Application no: 23/02096/HOU

PLANNING PERMISSION GRANTED

Demolition of garage and erection of two storey side, part single/part two storey rear extensions and rear dormer roof extension with installation of 3no. front rooflights to facilitate loft conversion. Installation of solar panels to front roofslope and dormer roof.

At 257 Raeburn Avenue Tolworth KT5 9DF

**CROSS SECTION PROPOSED**

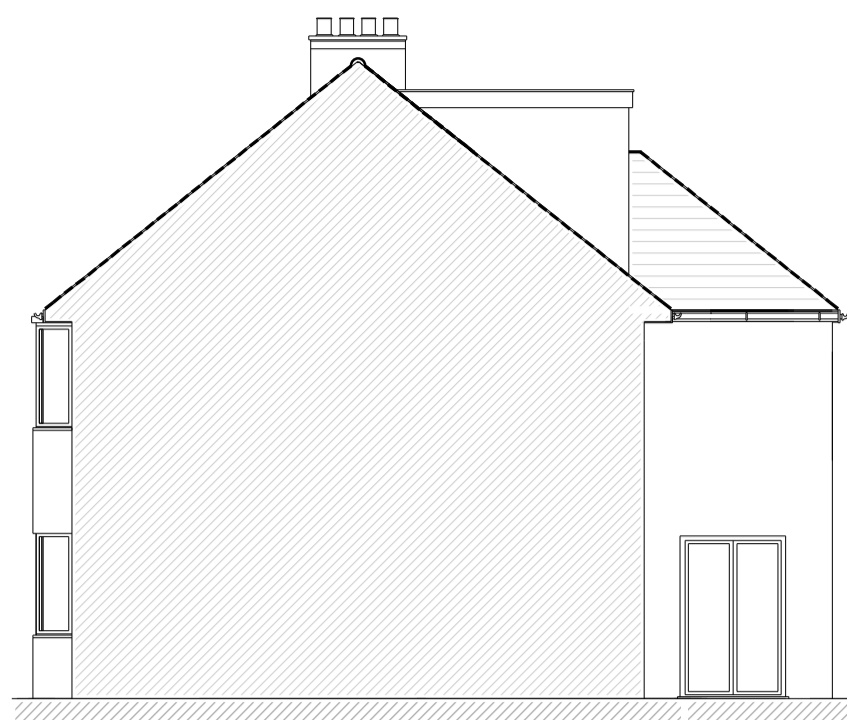
Whilst the proposed dormer would not be set down from the ridge line of the existing roof by at least 500mm or set in from the sides and eaves of the roof by at least 500mm, it would not feature on the front slope of the roof and this form of development would not be incongruous in the vicinity of Raeburn Avenue. Additionally, given that the dormer could be constructed under permitted development (even when including the roof of the two storey rear/side extension), officers consider that this would be a subsequent solution.

The proposed single storey rear extension would have a total depth of approximately 2.4m and a total pitched roof height of approximately 3.6m, falling in line with Policy Guidance 33, of the Residential Design SPD. Development of this type is prominent in the vicinity of Raeburn Avenue and the extension would not be seen from the streetscene.

The proposed single-storey rear extension would have a modest depth of approximately 2.4m and a total pitched roof height of approximately 3.6m. Officers have assessed the rear extension against neighbouring property No.259 Raeburn Avenue using the BRE 45 Degree Rule which demonstrates that there would not be significant harm in regard to loss of light to No.259.

**SIDE ELEVATION PROPOSED**

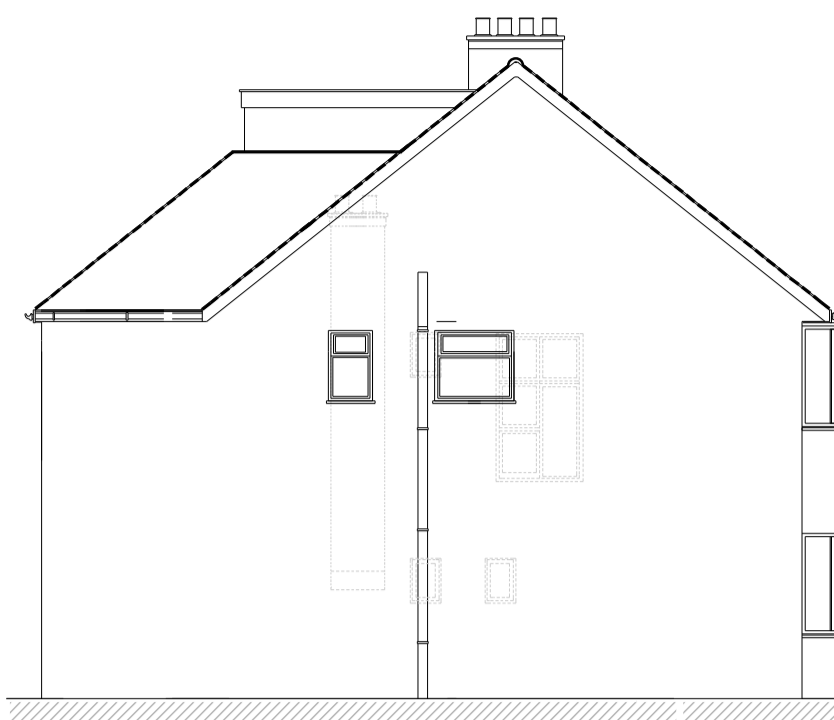
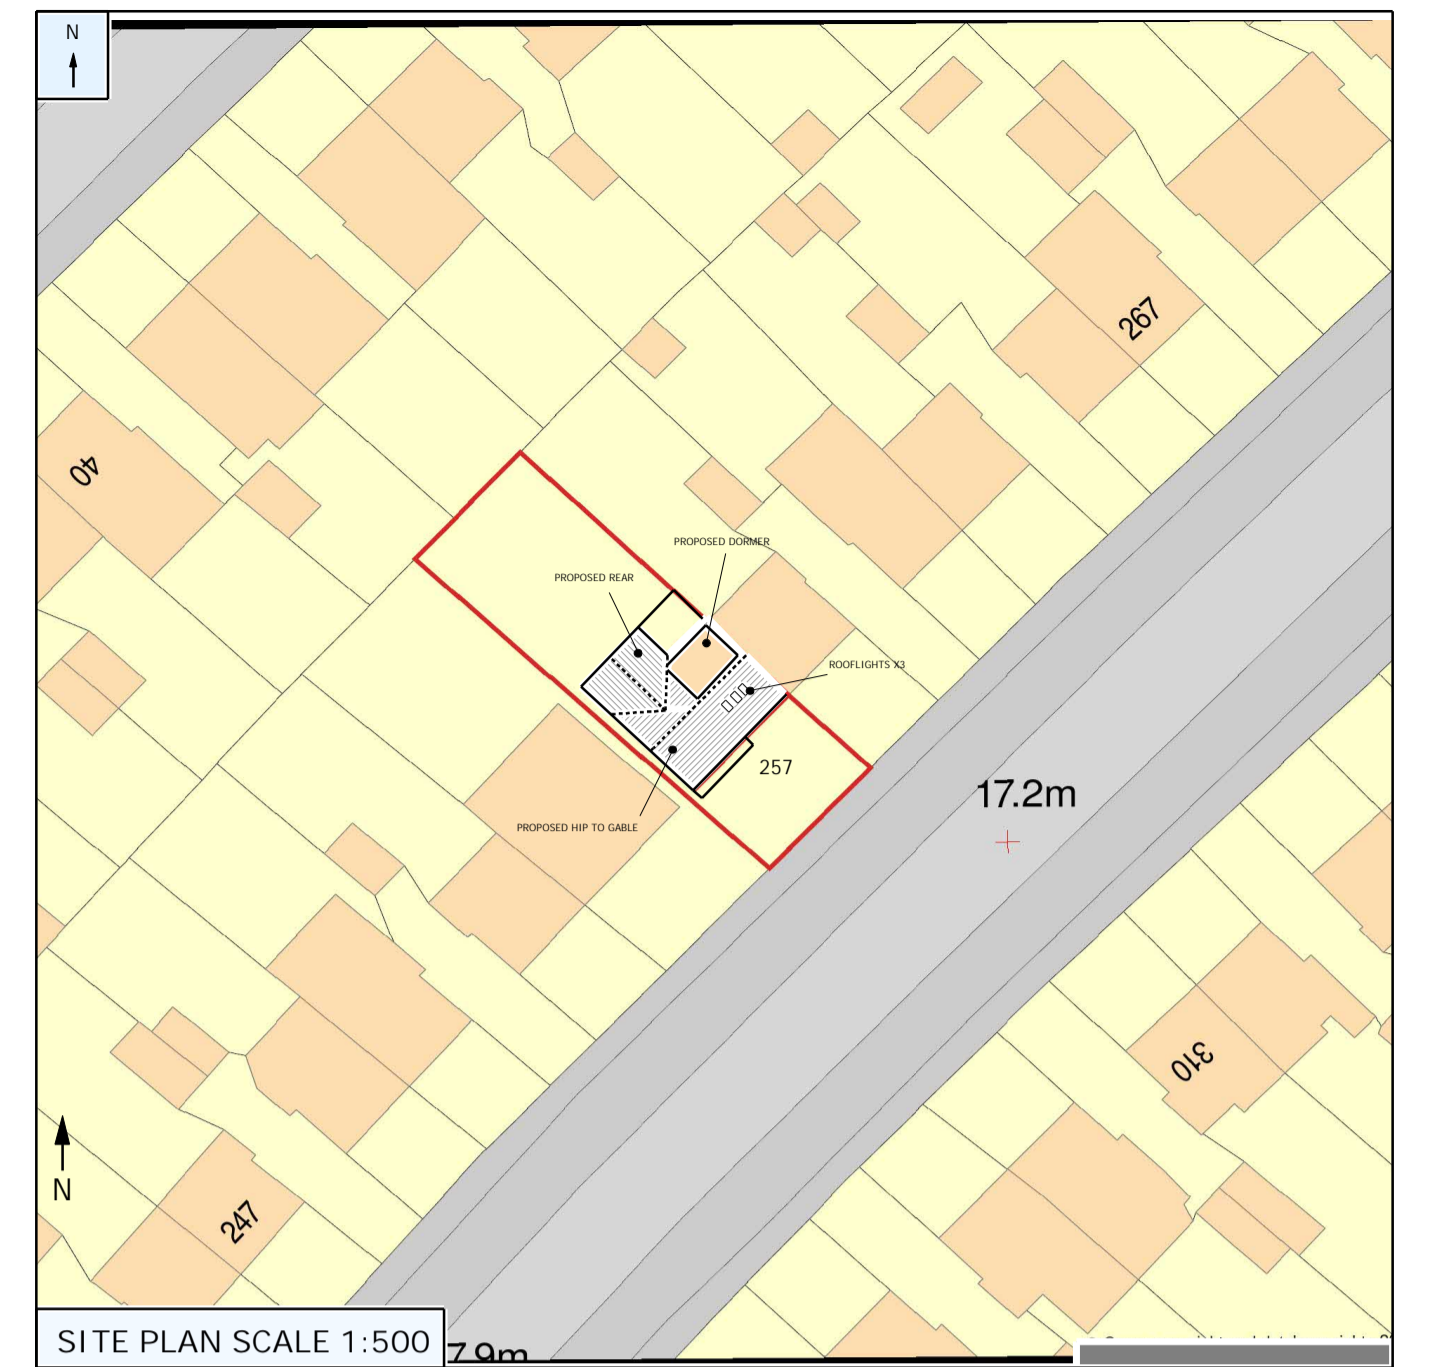
Officers acknowledge that the proposed two-storey side extension would only maintain approximately 800mm from the shared boundary with neighbouring property No.255 Raeburn Avenue and it would not be set back by at least 500mm from the front of the house. However, the existing garage already sits where the proposed two-storey side extension would sit, therefore, it would not be significantly different from the existing situation, in regard to positioning.

Officers acknowledge that the proposed two-storey side extension would have a width of approximately 2.5m and only leave a gap of approximately 500mm from the shared boundary with No. 255 Raeburn Avenue. No.255 has 4 windows on the side elevation facing No. 257 which have been assessed in relation to impact on light and privacy.

The windows on the ground floor serve a playroom which would be impacted by the proposed development, however, the playroom is also served by a window to the front elevation, therefore, the proposed side extension would not cause significant harm to the ground-floor playroom. In regard to the window that serves a room on the first floor, officers acknowledge that the proposed side extension would impact the room in regard to loss of light, however, the existing window positioning on the first-floor level of both No.255 and No.257 breaches the BRE 25-Degree Rule. Additionally, the proposed side elevation windows would be positioned to slightly resemble No.255 windows on the first floor. Therefore, there would not be a significant loss of light as a result of the two-storey side extension. In the event of an approval, officers consider that a condition to ensure that these windows are obscure glazed would be required, in the interest of protecting the privacy of neighbouring properties.

5. Prior to beneficial occupation of the development to which this permission relates, any windows inserted at first floor level and above in the south-western elevation shall be constructed so that no part of the framework less than 1.7m above finished floor level shall be openable. Any part below that level shall be fitted with and permanently retained in obscure glazing to a minimum of level 3 on the standard scale. Any film used to achieve the requisite obscurity level shall be non-perishable, tamper-proof, and shall be replaced immediately in the event that it ceases to result in obscurity to level 3.
